Please ask for: Ms Iqraa Malik
Email: iqraa.malik@terraquest.co.uk
Telephone: 01212341390
Our Ref: FG/15/21/PL
Your Ref:
Date: 12th February 2021

Application for Planning Permission

Development: Conversion of Garage into bedroom & Replace existing conservatory roof to solid roof with Velux
Location: 1 Ferring Grange Gardens Ferring BN12 5HS

PROJECT No.1 , Morton	DRAWING NO. 1467-P001	SCALE 1:1250 @ A3	12	B
ADDRESS No.1 Ferring Grange Gardens	DRAWING TITLE Location & Orientation	DRAWN BY CRE8TIVE LINES - ROZ NOWAK	Feb	2021
ARUN DISTRICT COUNCIL FG/15/21/PL BN12 5HS

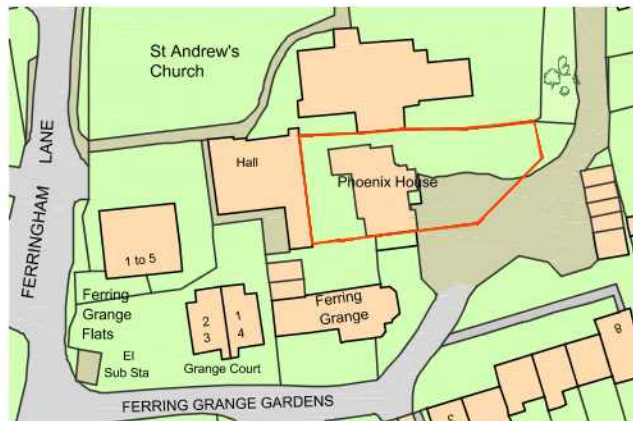
Location Plan: You are required to have a solid red outline around the entire site. Please amend

PROJECT No.1 , Morton	DRAWING NO. 1467-P002	SCALE 1:500 @ A3	12	B
ADDRESS No.1 Ferring Grange Gardens	DRAWING TITLE Existing & Proposed Block Plans	DRAWN BY CRE8TIVE LINES - ROZ NOWAK	Feb	2021

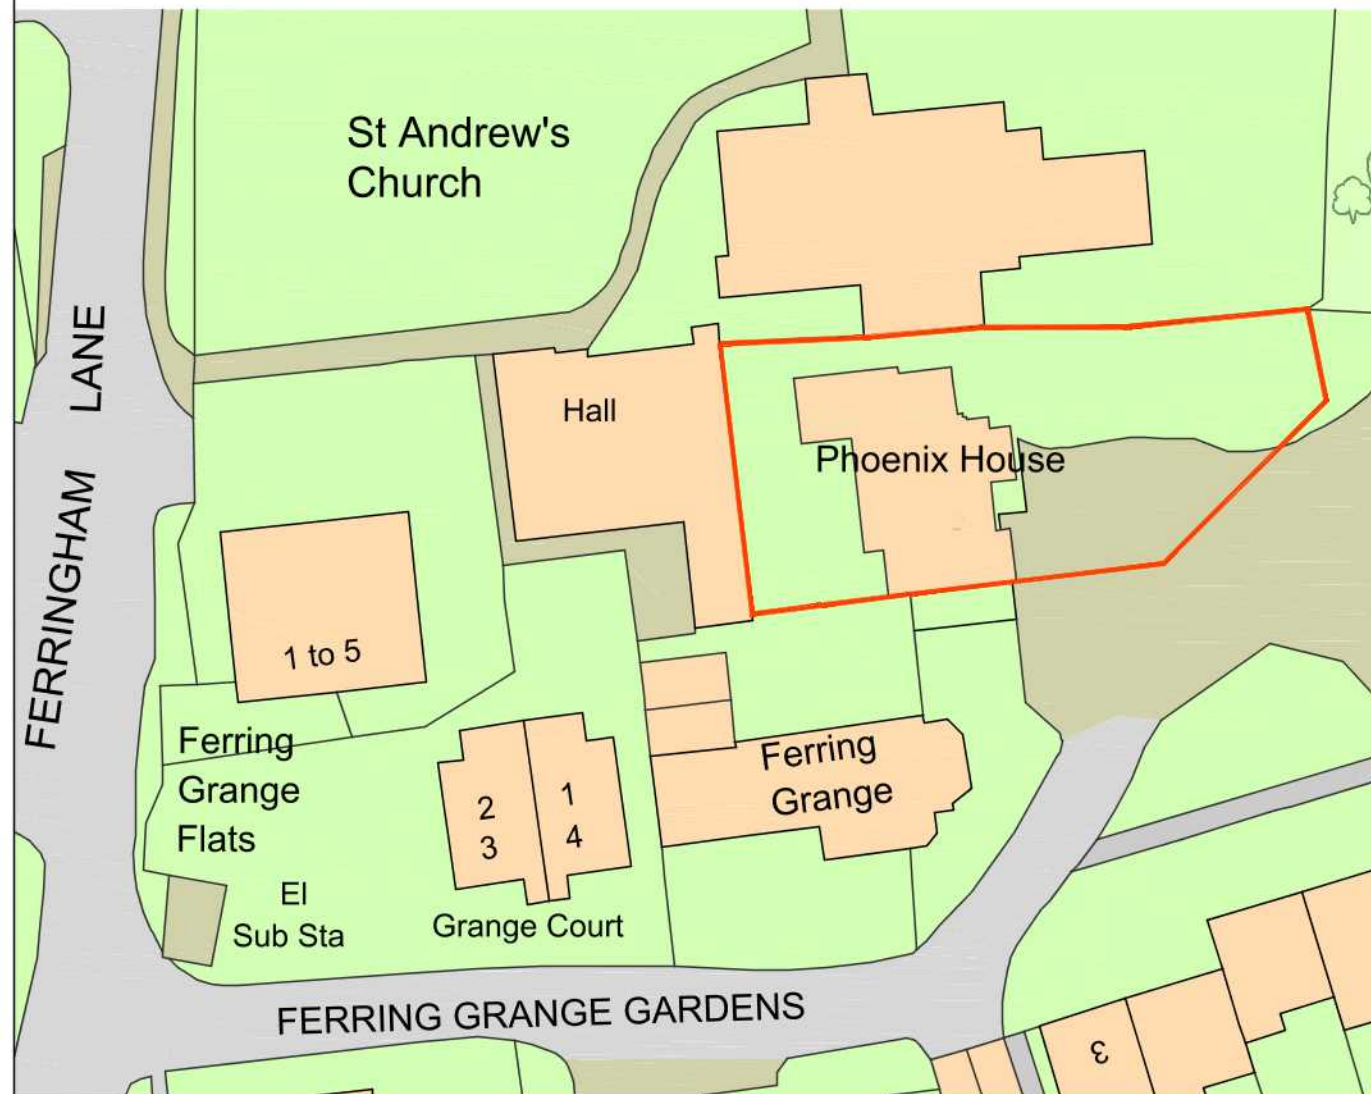
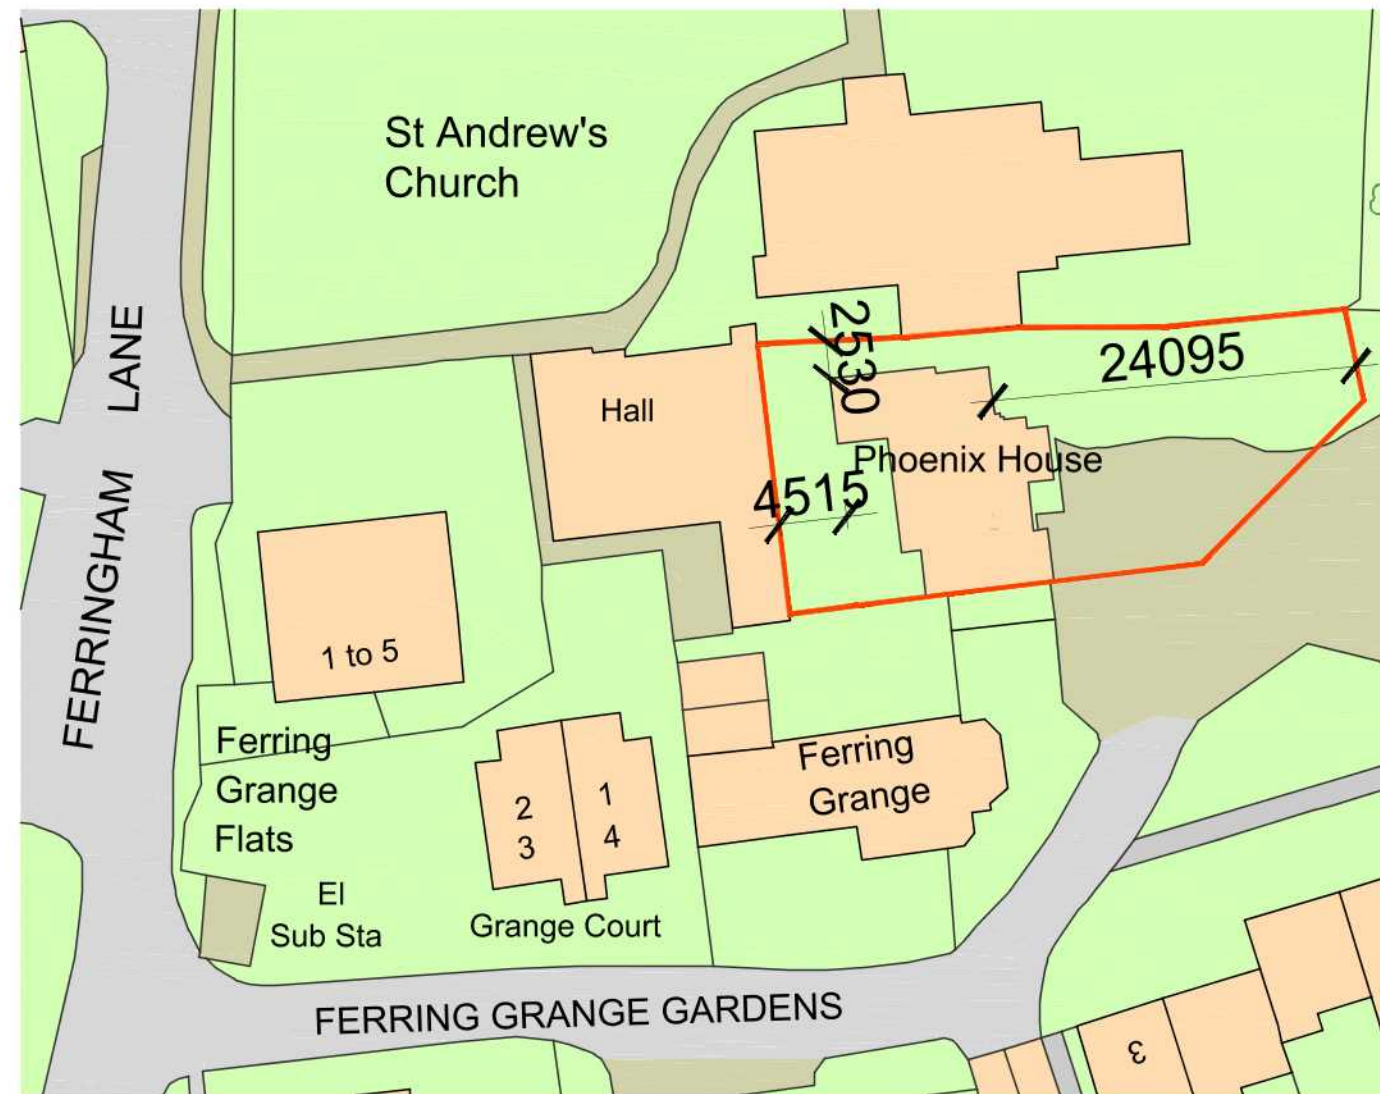
Dimensions: You are required to include dimensions on the block plan from the proposed works to all site boundaries. Please amend
